Phone: 0300 123 6780
Email: developeras@lancashire.gov.uk
Your ref: 3/2025/0772
Our ref: 3/2025/0772/HDC/KW
Date: 03 October 2025

Location: St Cecillas RC High School Chapel Hill Longridge PR3 2XA
Proposal: by conditions 4 (landscaping), 5 (landscape/habitat management and monitoring plan) and 7 (details of an alternative secure cycle storage) from planning permission 3/2024/1020.
Grid Ref: 360311 438775

Project			
St Cecilia's RC High School Longridge			
Title			
Proposed Cycle Shelters			
Scale	1:20 @ A3	Date	23.09.25
Drwg No	4974 /P12	Drawn	
GREENHALGH and WILLIAMS		3 Manchester Road Bury BL9 0DR Architects and Building Surveyors Tel : 0161 764 6995

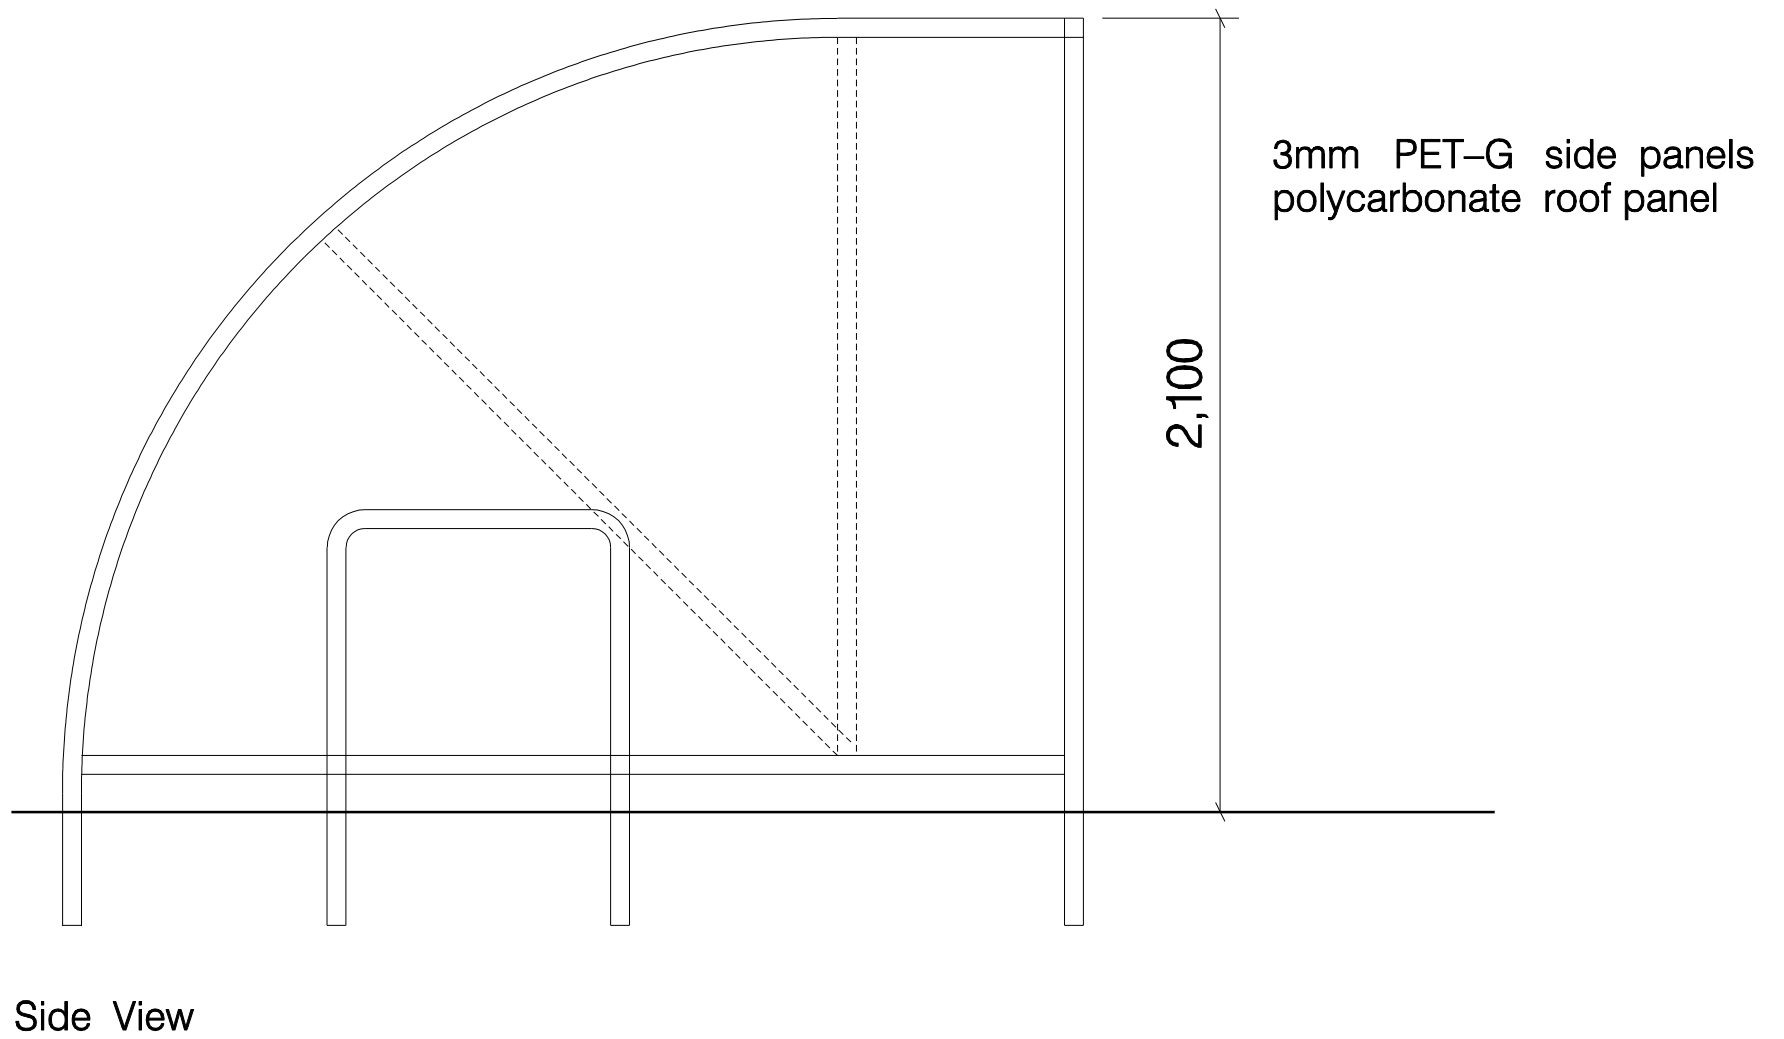
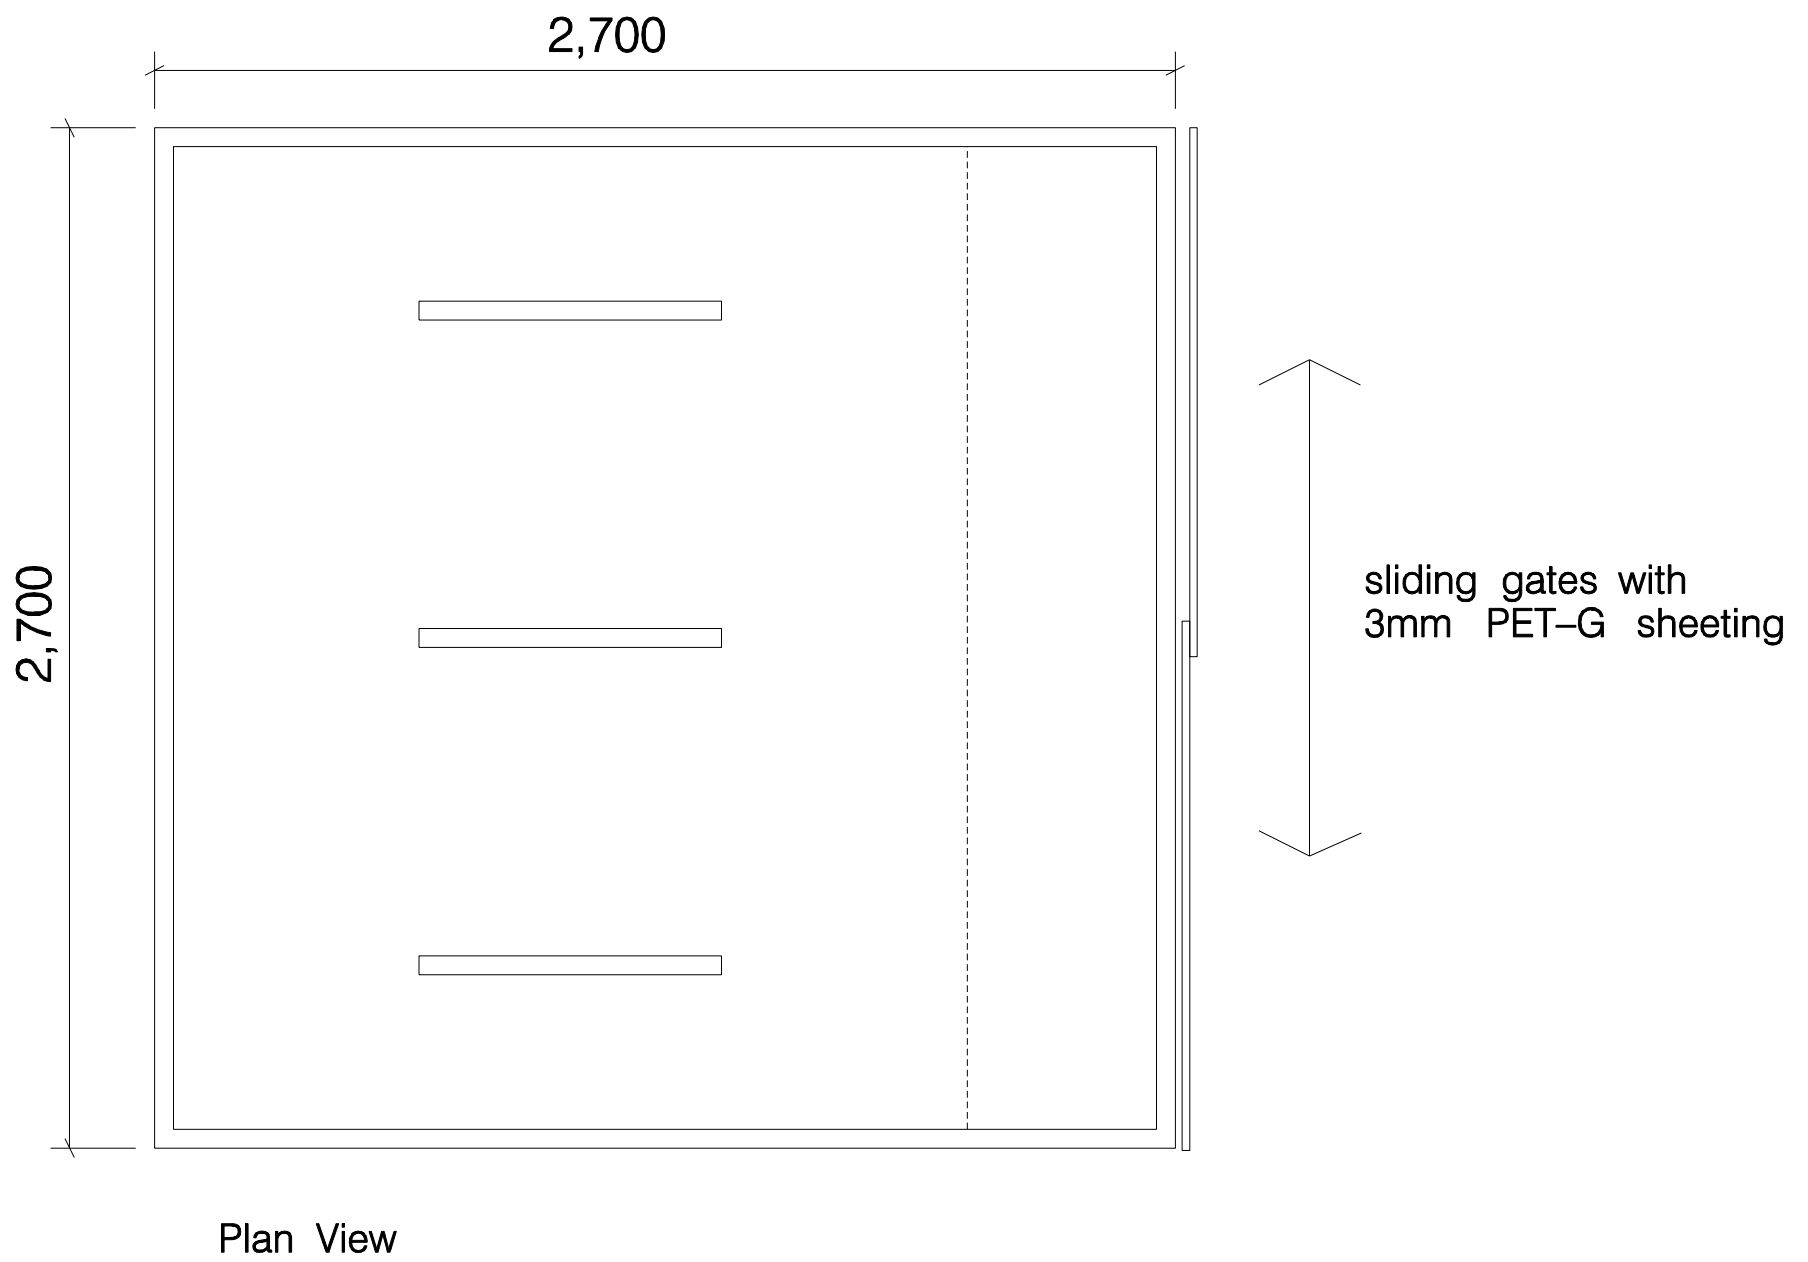
The Highway Development Control Section of Lancashire County Council has no objections to the approval of details reserved by condition 7. The LHA has reviewed the information provided within the plan titled Proposed Cycle Shelters and notes that secure covered cycle storage will be provided within 3 separate units, providing a total of 18 cycle storage spaces.
